June 30, 2022

Reference: Engineering Services
Oak Haven – Lot 23
Holly Springs, NC
TE&D Project No.: 2201-020566

As requested, a representative of Tyndall Engineering & Design, PA (TE&D) was on-site to observe the following item(s):

FOUNDATION PLAN
SCALE: 1/4"=1'-0"

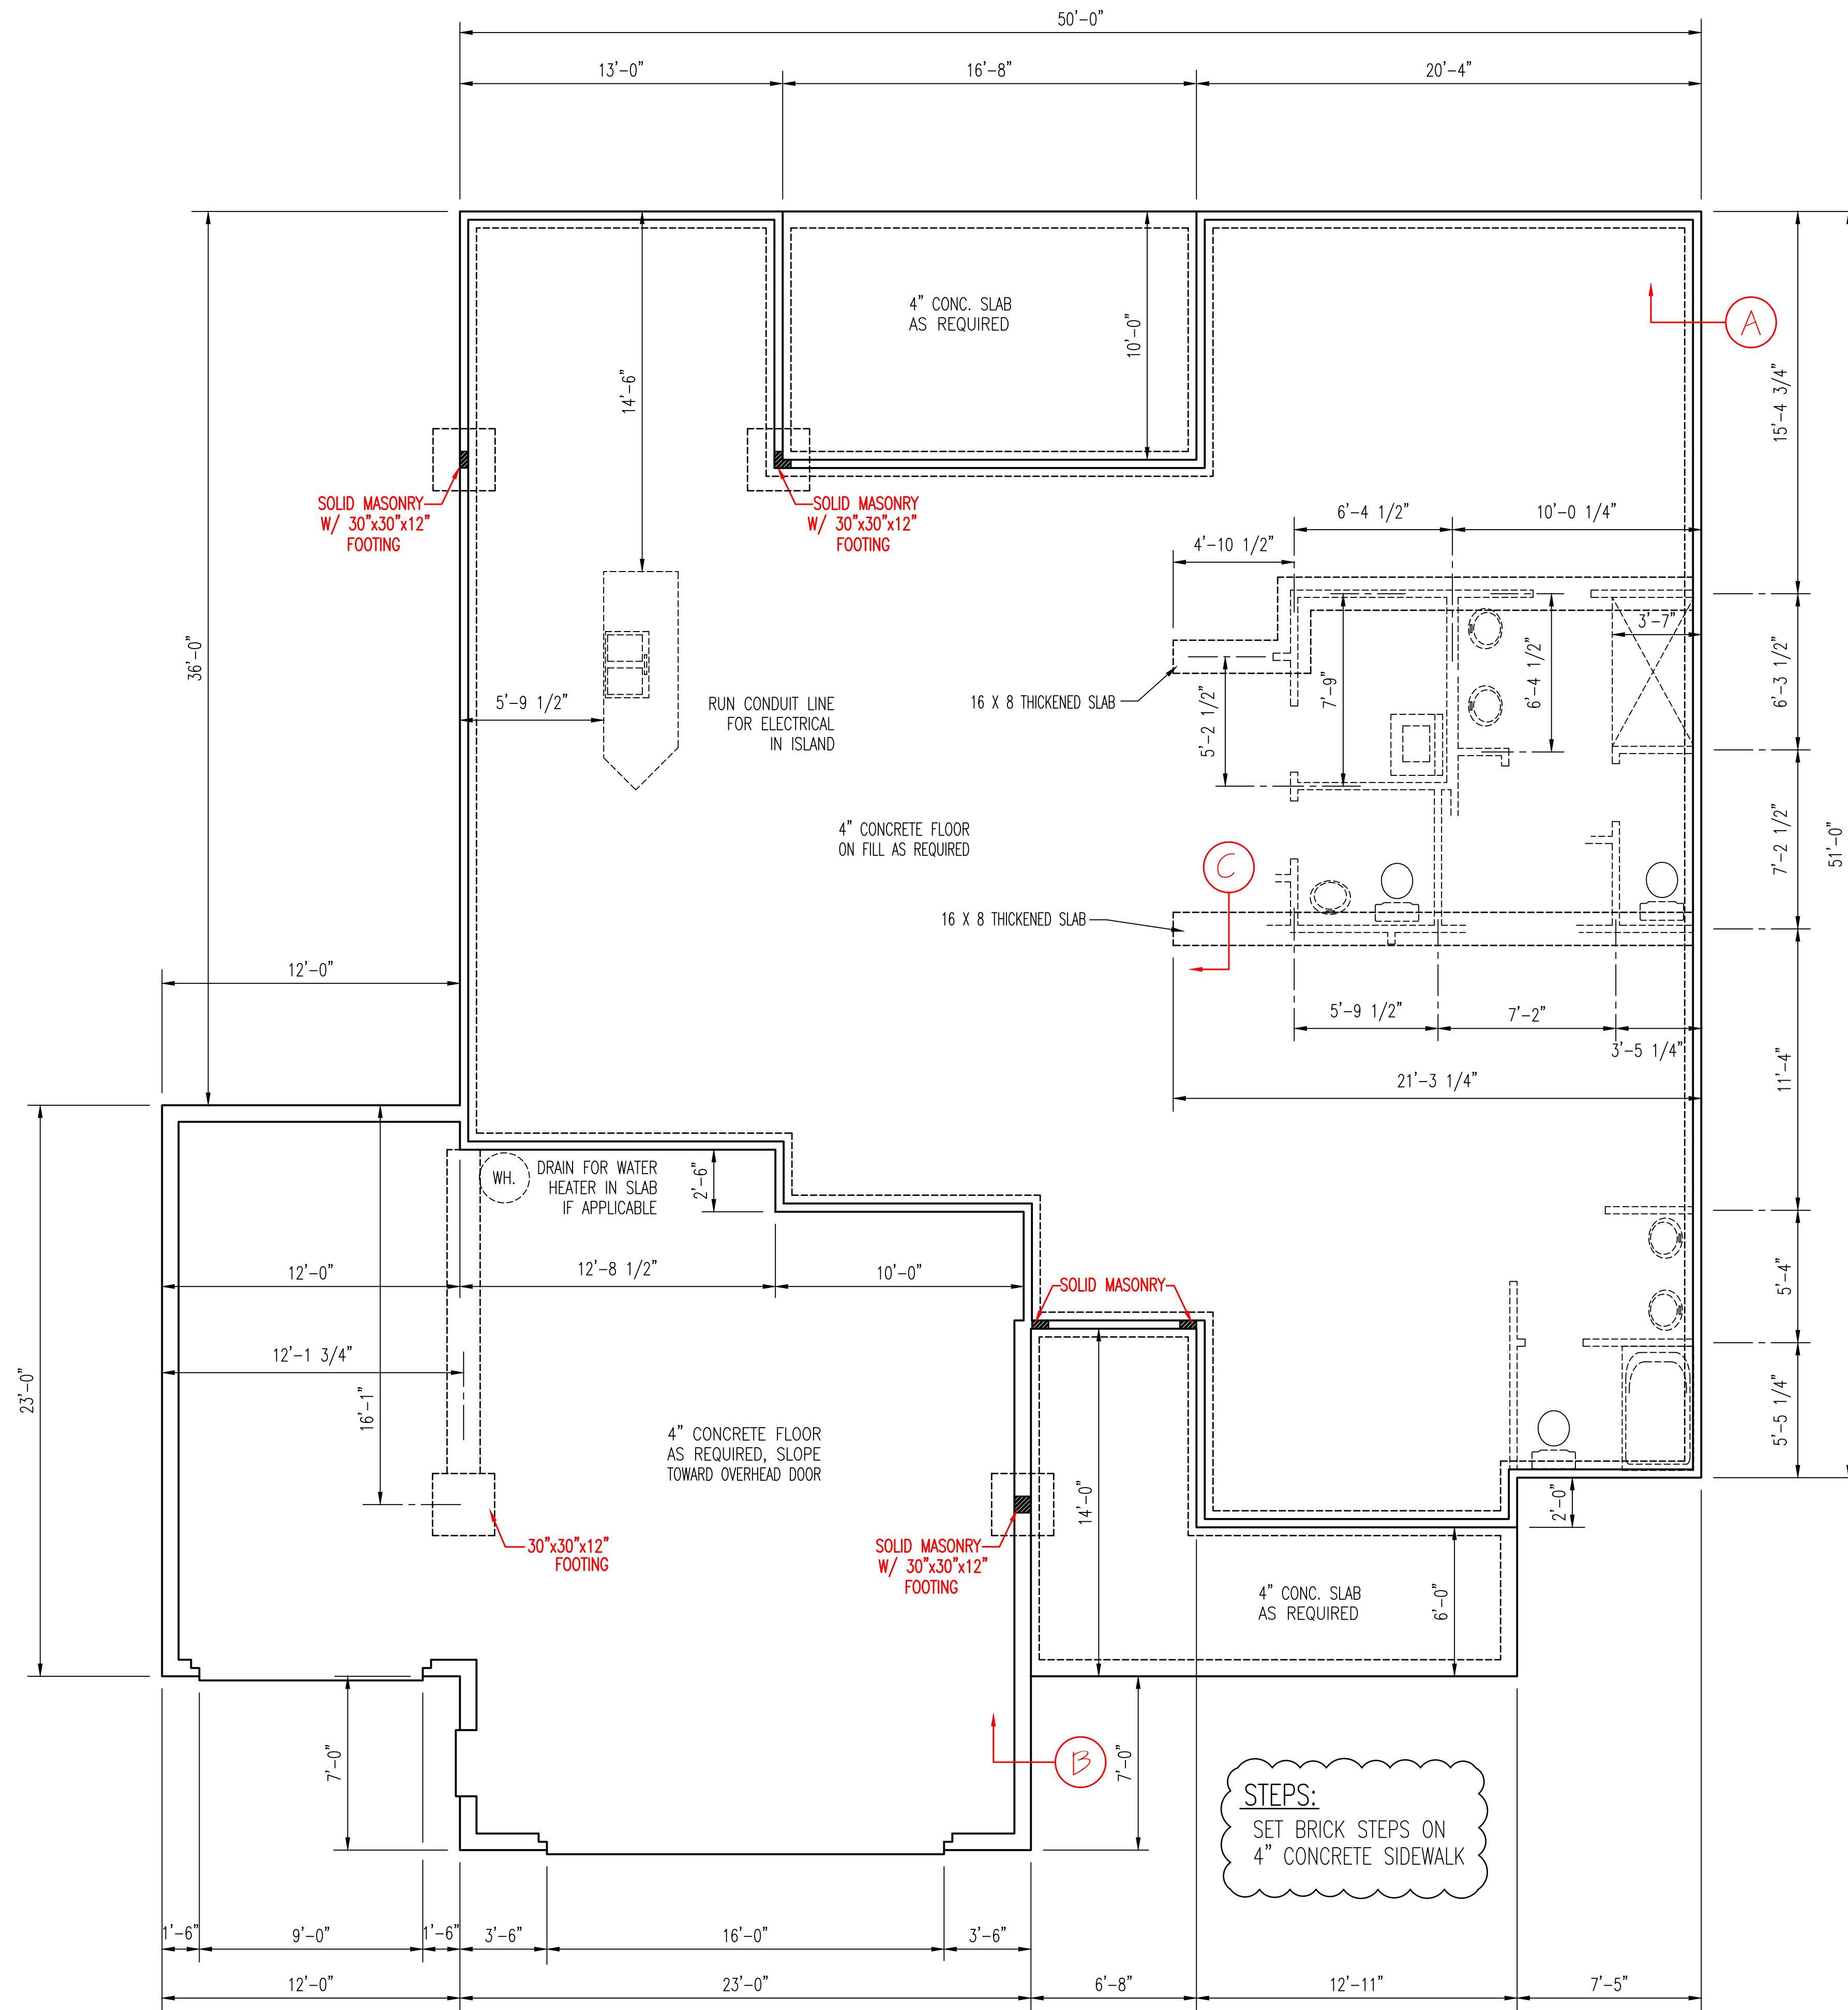
- 1) Missing foundation projection at the front right wall.

- 1) Based on our observations and analysis, the projection of 0” to 2” is not suitable. The footing is to be repaired with (1) of the following options per the attached details. Upon completion, the newly added section of concrete will provide the required support for the anticipated loading conditions.

Site of inspection and area to be repaired.
Approximately 4'-0" of footing to be repaired at the 7'-5" bumpout.
